Colston Budd Hunt & Kafes Pty Ltd

14 February, 2013

**RE: PROPOSED REDEVELOPMENT
OF HURSTVILLE PRIVATE HOSPITAL**

1. As requested, we are writing to set down our responses to matters raised by the Department of Planning following the exhibition period for the above development. We have previously prepared a report¹ which was submitted with the Part 3A application.
2. In a letter dated 10 January 2013, the Department of Planning has raised a number of matters relating to transport and accessibility. These matters, and our responses, are provided below.

DA-080

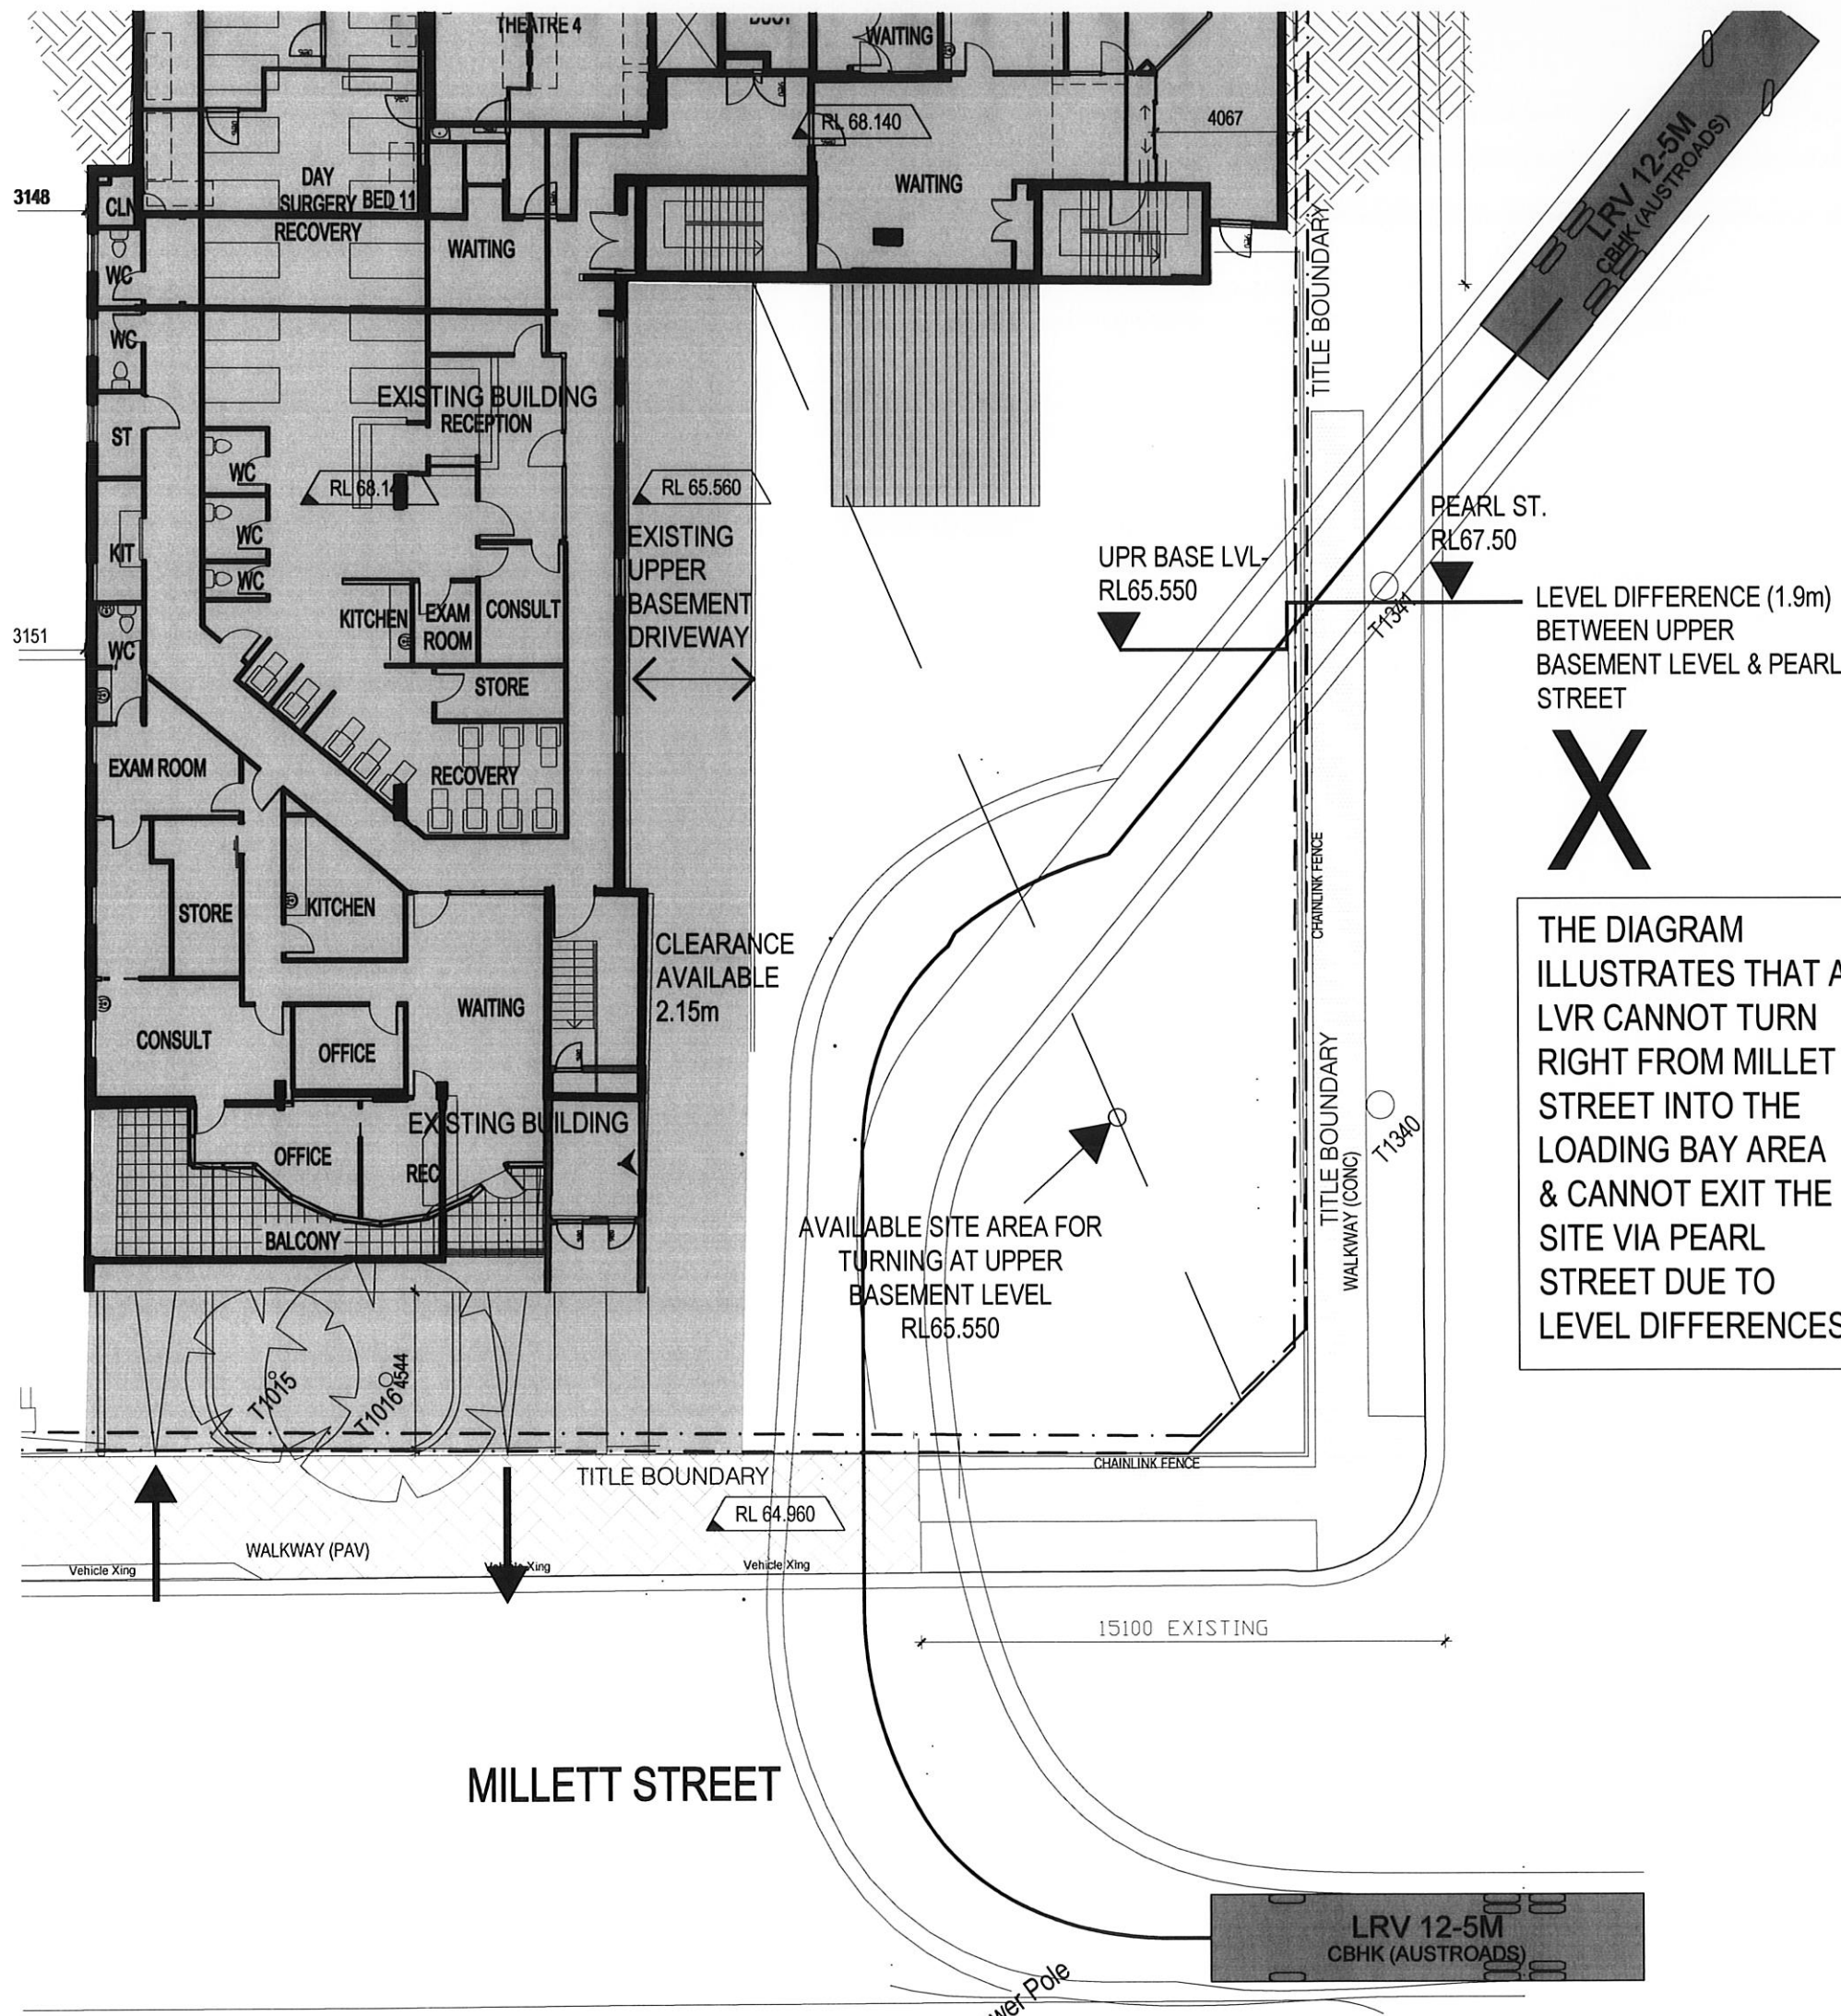
- *Provide more information about how the servicing of the proposed development is to be achieved and in particular, demonstrate how loading and unloading by vehicles is to occur in a forward direction only. If there is a need for reversing manoeuvres from Millet St, justify why the design cannot be amended to include forward only servicing and provide detailed documentation as to the frequency of any such servicing (including likely arrival and departure times and vehicle type) and that the frequency is in accordance with the Australian Standard for Parking Facilities by specific reference to relevant provisions.*
10. The first part of this matter is being addressed by the project architect. To provide for large service vehicles to enter and exit the site in a forward

direction, part of the existing car park and building fronting Millett Street would need to be demolished, as demonstrated in the attached drawings (DA-080, DA-081 and DA-082) prepared by the architect.

TITLE:
ACCESS TO NEW SITE LAODING BA
OPTION 1

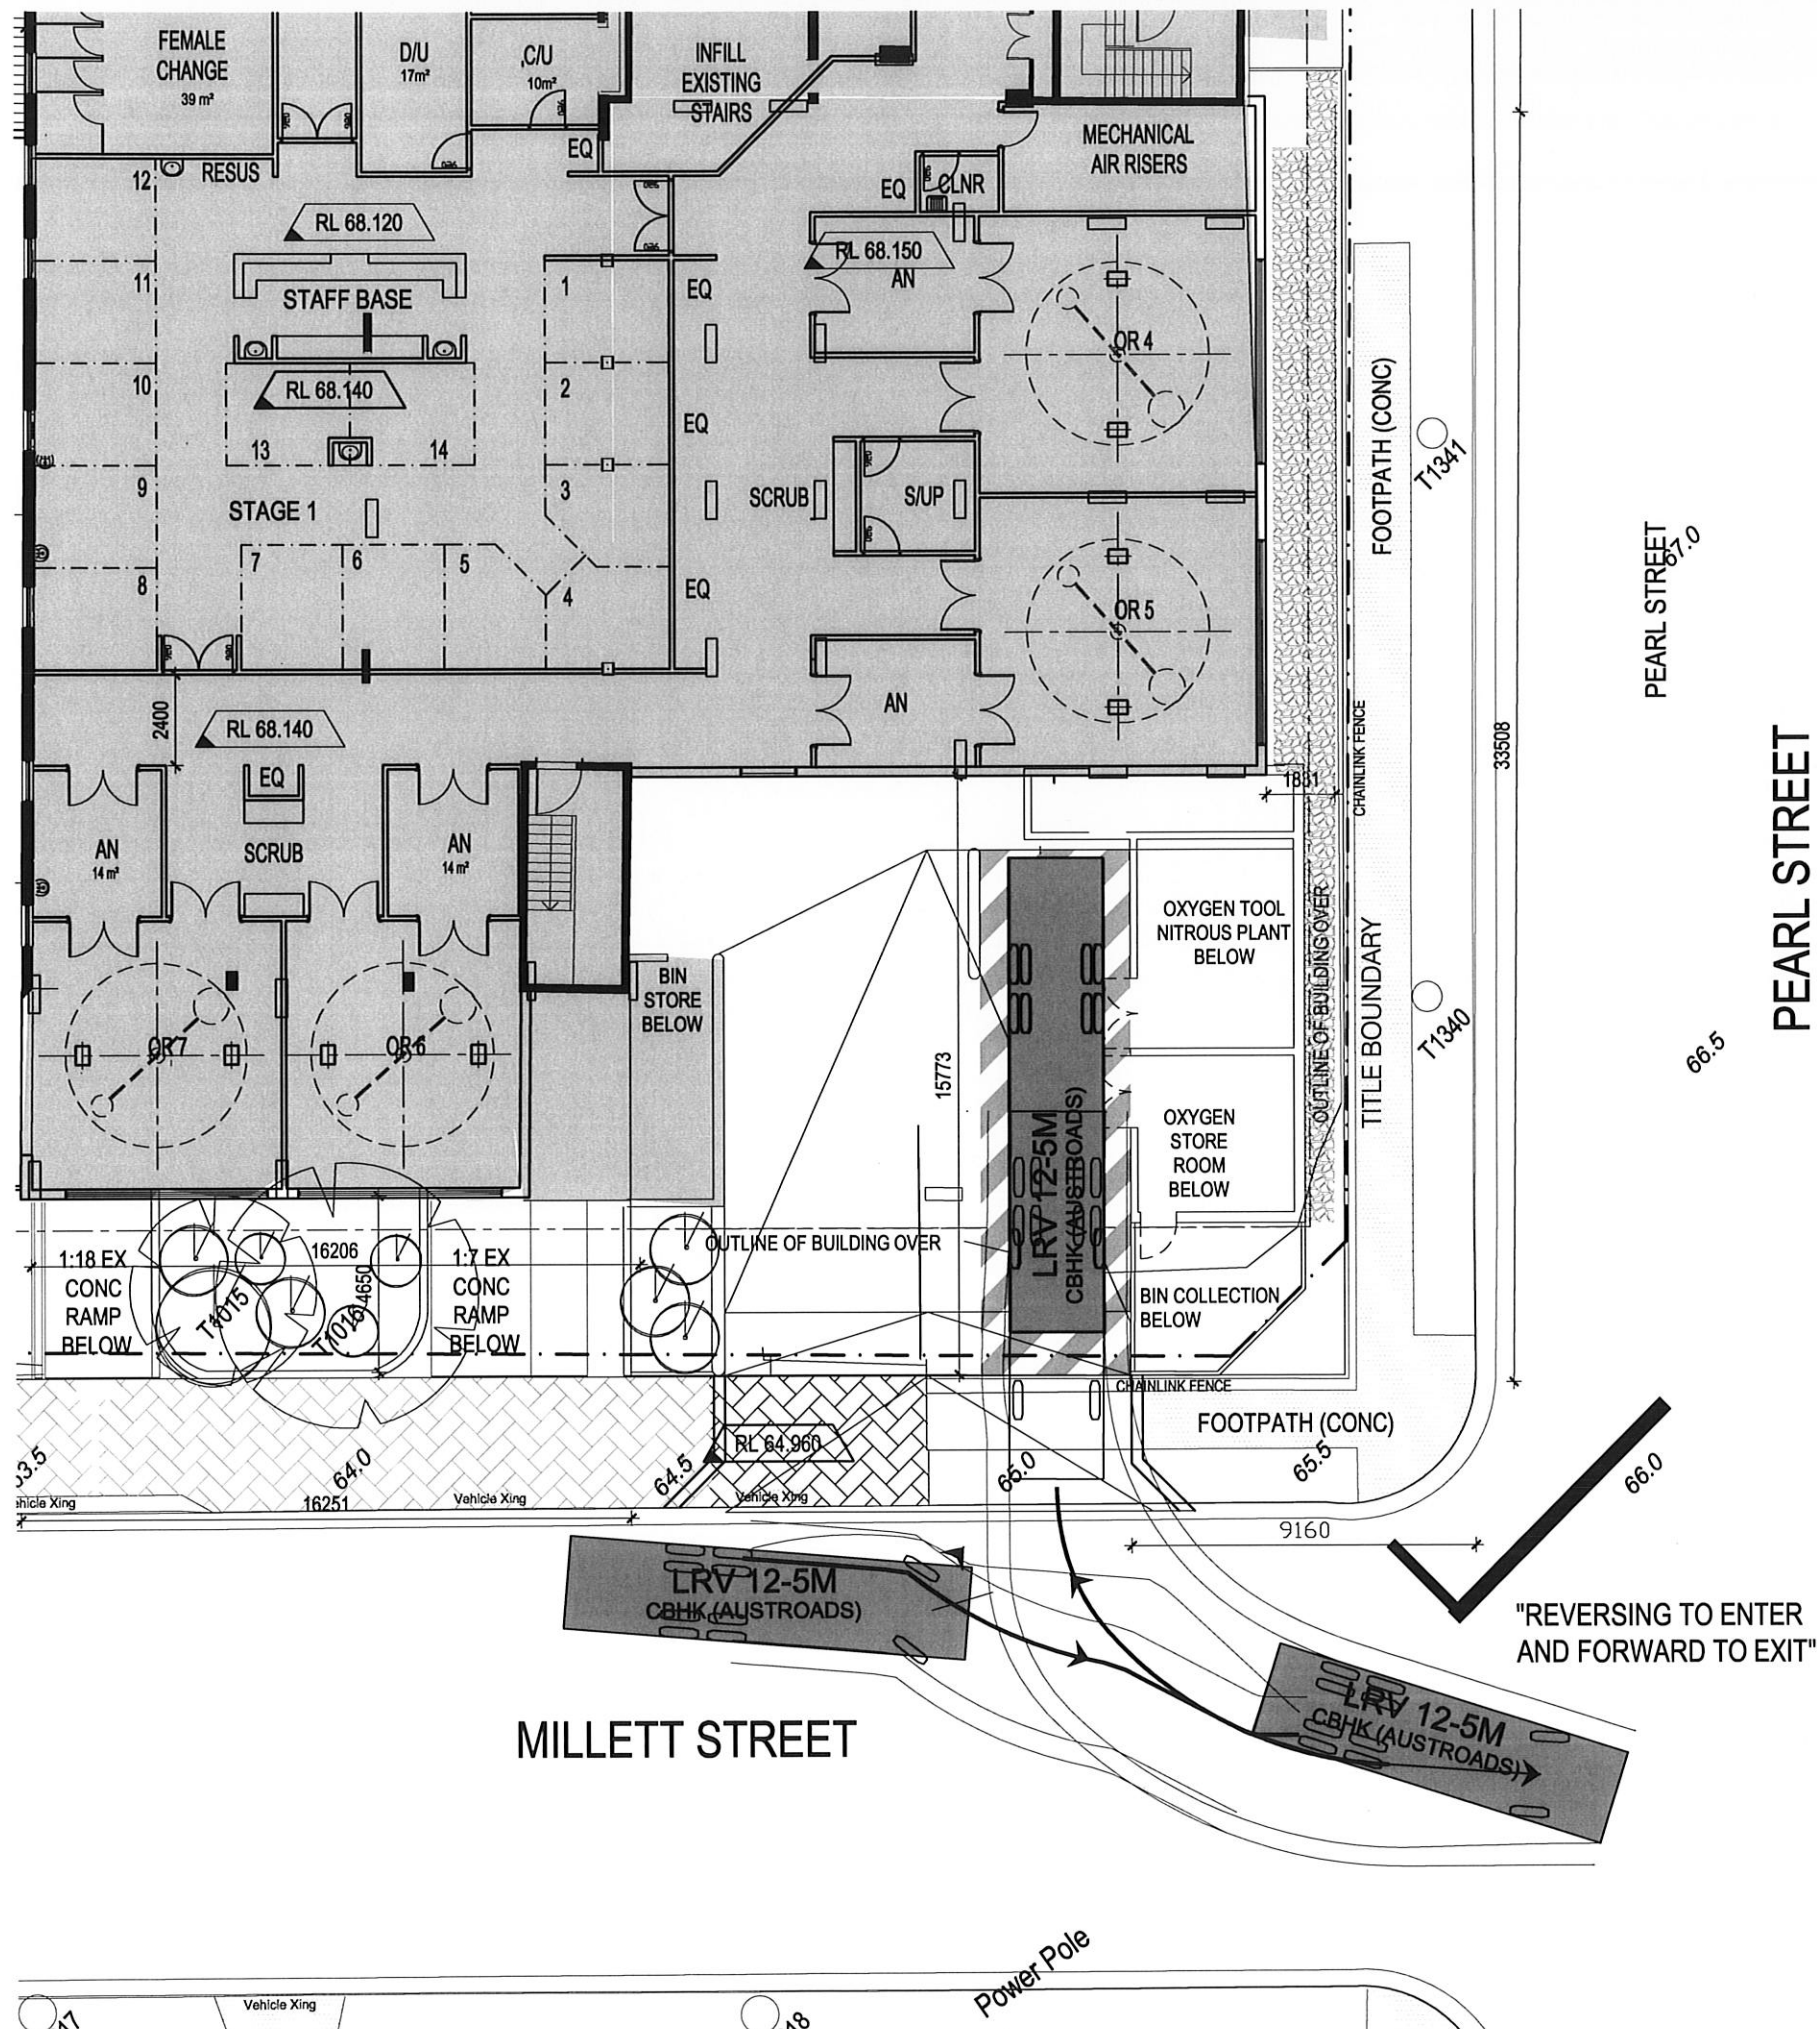
- *Amend the design to consolidate and minimise the number of vehicle entrances and exits and crossovers on Millet St. Justify any need for more than one exit and one entry on Millet St.*
3. The existing and proposed driveways on Millett Street are shown in the attached drawings prepared by the architect (DA-085 and DA-086). The number of driveways on Millett Street will reduce.
 - *Demonstrate that driveways comply with Hurstville DCPs and with the Australian Standard for Parking Facilities by specific reference to the relevant provisions of both.*

7. Additionally, the driveway should provide for turns by service vehicles entering and exiting the development. Swept paths are attached in figures prepared by the architect (DA-083 and DA-084) show that the driveway will accommodate these turns.

15. It is therefore anticipated that there would be some two to four small to medium rigid trucks per day which may reverse between the site and Millett Street. The Australian Standard for Parking Facilities (Part 2: Off-street commercial vehicle facilities), AS 2890.2 – 2002, indicates that “regular service” (more than once per day) from a “minor road” (road carrying predominantly local traffic, such as Millett Street) should occur in a way that only one reverse manoeuvre occurs either to or from the street. The design provides for vehicles to enter and exit the site using one reverse manoeuvre, as shown in the attached drawings DA-083 and DA-084, prepared by the architect.
